SLAF
C/O Suffolk Highways

Your Ref: EN010012
Our Ref: Registration ID 20026008

Representation to the Planning Inspectorate by the Suffolk Local Access Forum in response to the Development Consent Order by NNB Generation Company (SZC) for the proposed Sizewell C Nuclear Power Station. Planning Inspectorate Reference: EN010012

DRAWING TITLE:
 SUFFOLK COAST PATH AND FUTURE ENGLAND COAST PATH DIVERSIONS - CONSTRUCTION PHASE

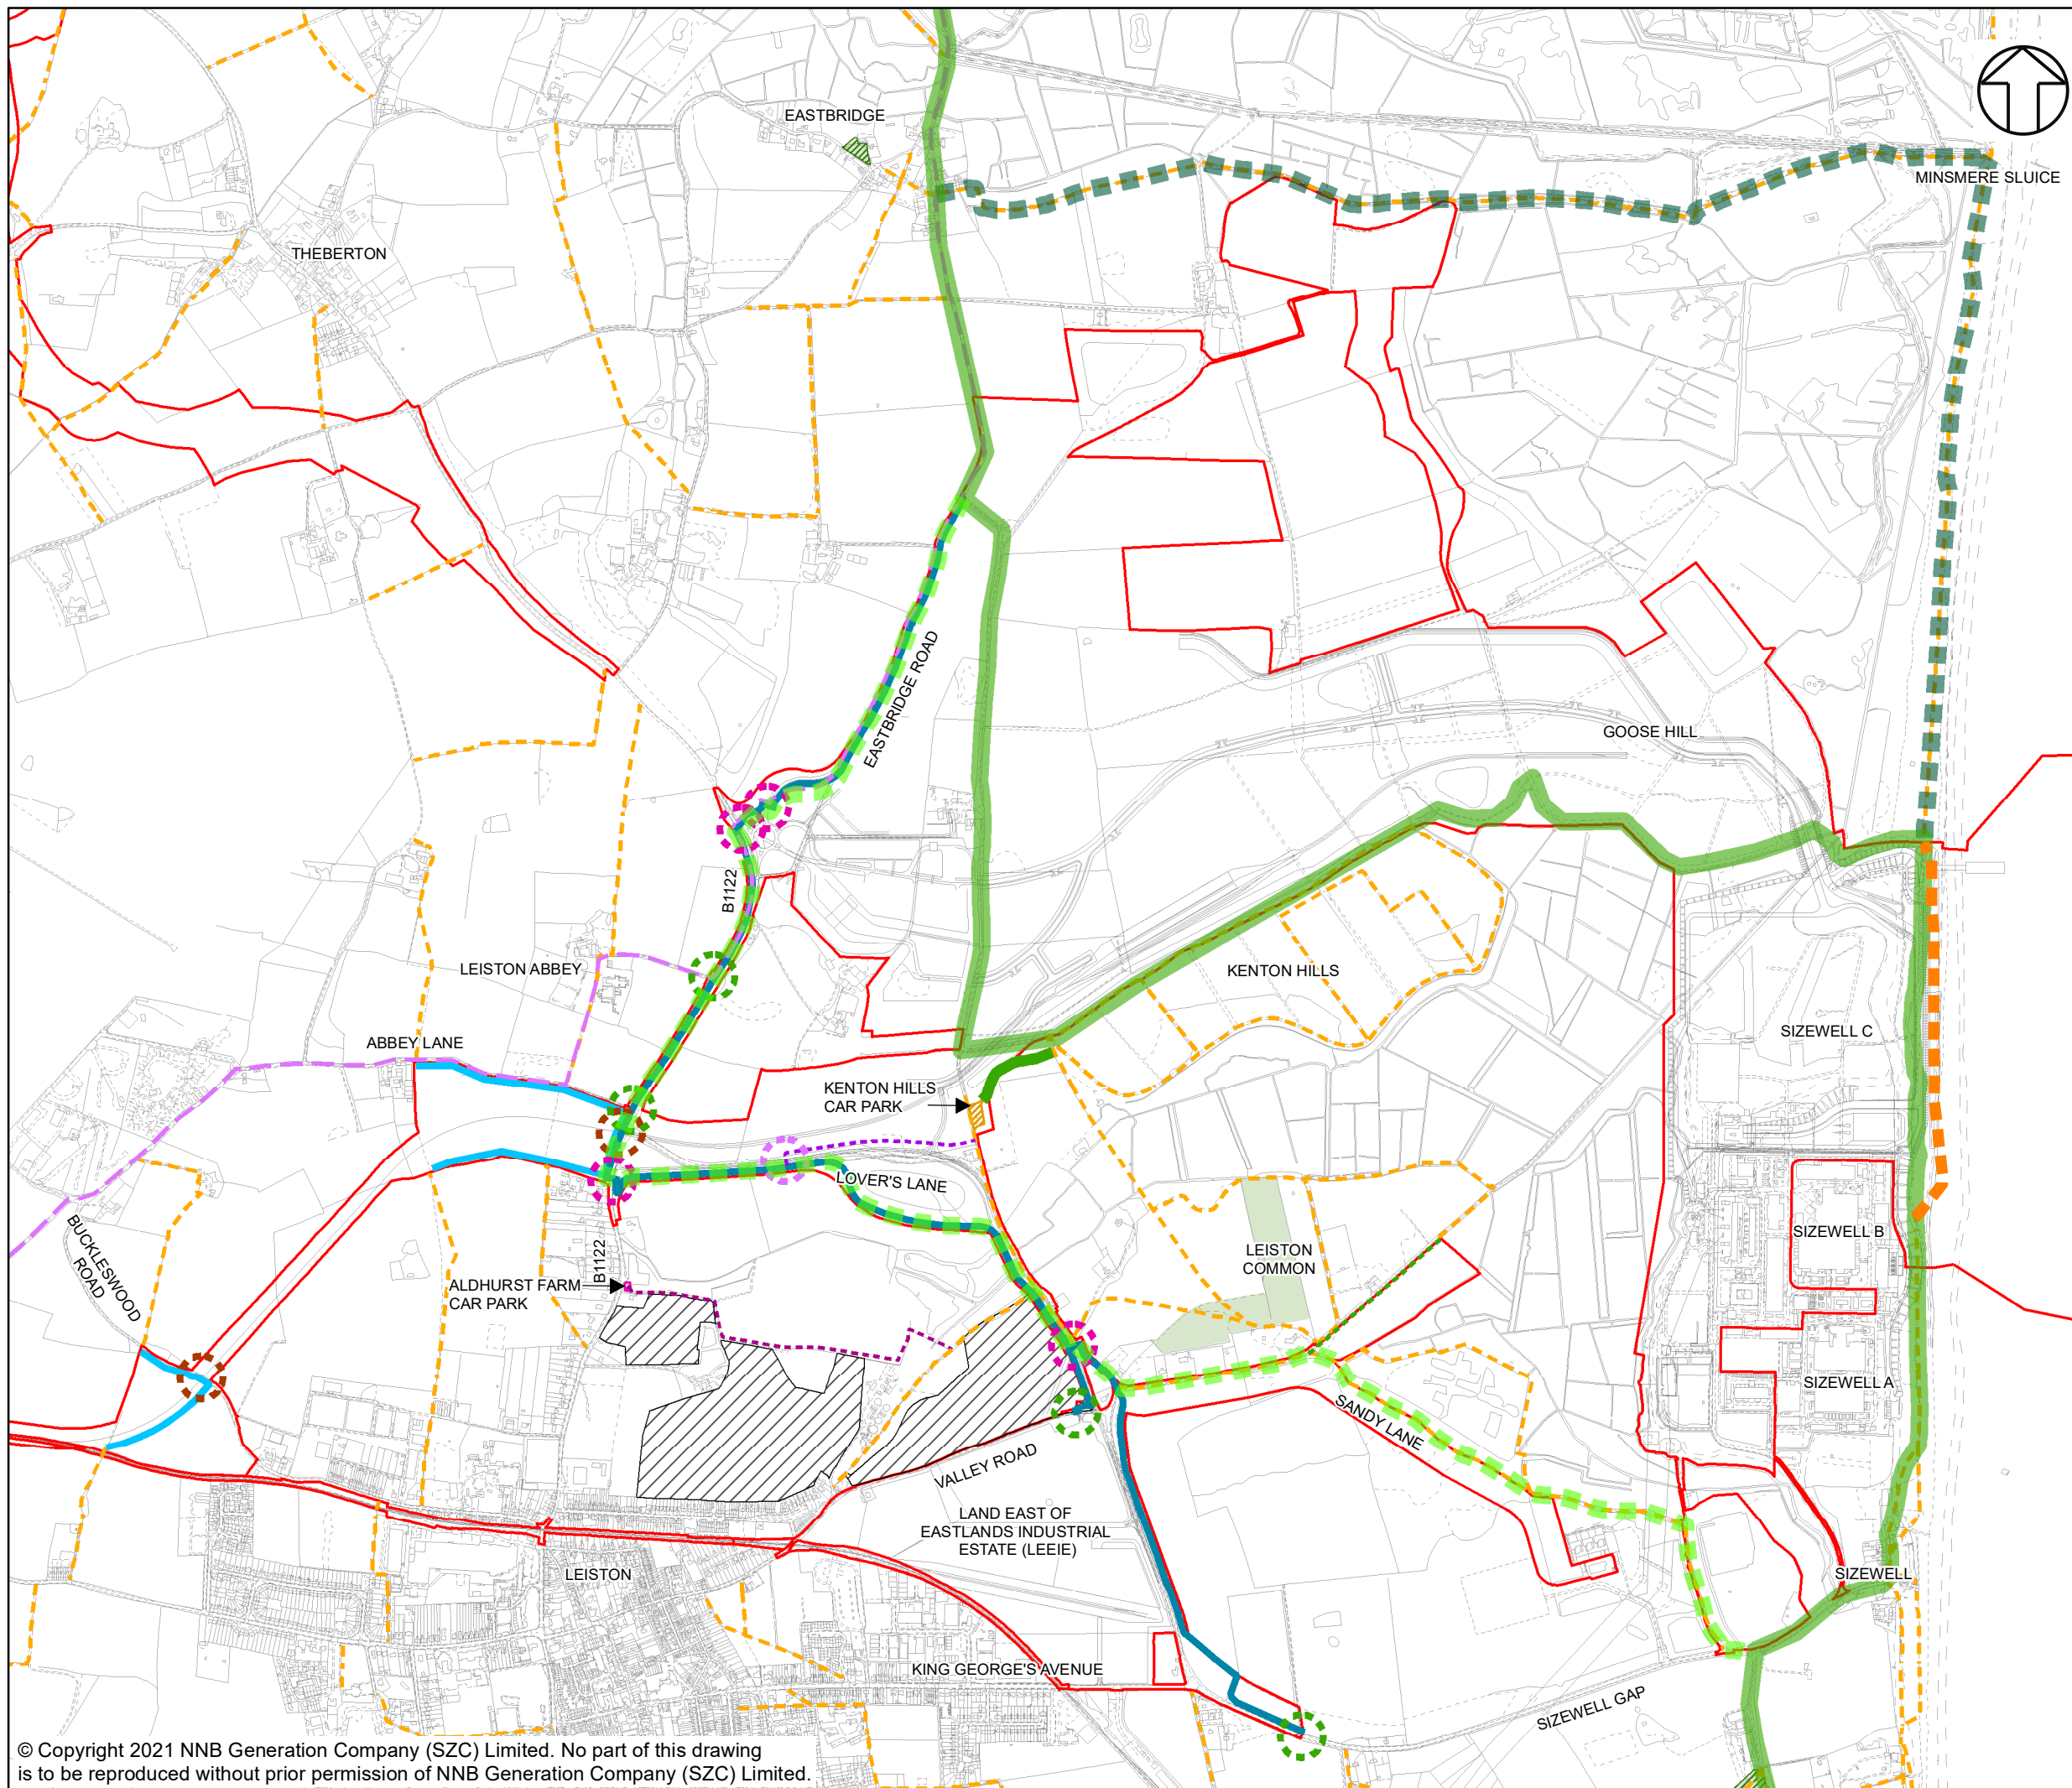
What is now the Suffolk Coast Path will shortly become part of the England Coast Path. Regrettably the route suggested by EDF is along soft sea defences which over time could disappear with coastal erosion. SLAF therefore requests that the definitive route of the path is moved onto the top of the new hard sea defences being constructed to protect the new power station.

During the construction of the proposed new sea defences we would expect the Coast Path to remain open. In the longer term we have concerns that the path being squeezed between the new dunes and the beach that if over time the beach erodes then the path could be lost when roll-back finally reaches the power station boundary.

We are especially concerned about the soon to be England Coast Path. As SLAF understands it, during the construction of the new sea defences in front of Sizewell C the path may be diverted down the beach towards the sea. This raises safety issues, for instance if there is a high spring tide. We would also expect any such diversion to be accessible to all users with matting or something similar laid over the shingle to provide a level surface. Once the sea defences are in place, we would like to see the definitive legal route of the public right of way moved to the top of the defences which should be of sufficient width to accommodate this. This would future-proof the route against any long-term erosion issues.

With the possibility of closures of the Coast Path to enable beach landing of construction materials, these should be kept as short as possible and the frequency and duration notified well in advance to all interested parties. SLAF is still concerned that proposed long diversion route could cause problems to people who are walking to a tight schedule and the extra time taken for that this route could cause them accommodation problems at the end of the day. We therefore would see the provision of a shuttle minibus between Sizewell and Dunwich as an alternative of great benefit.
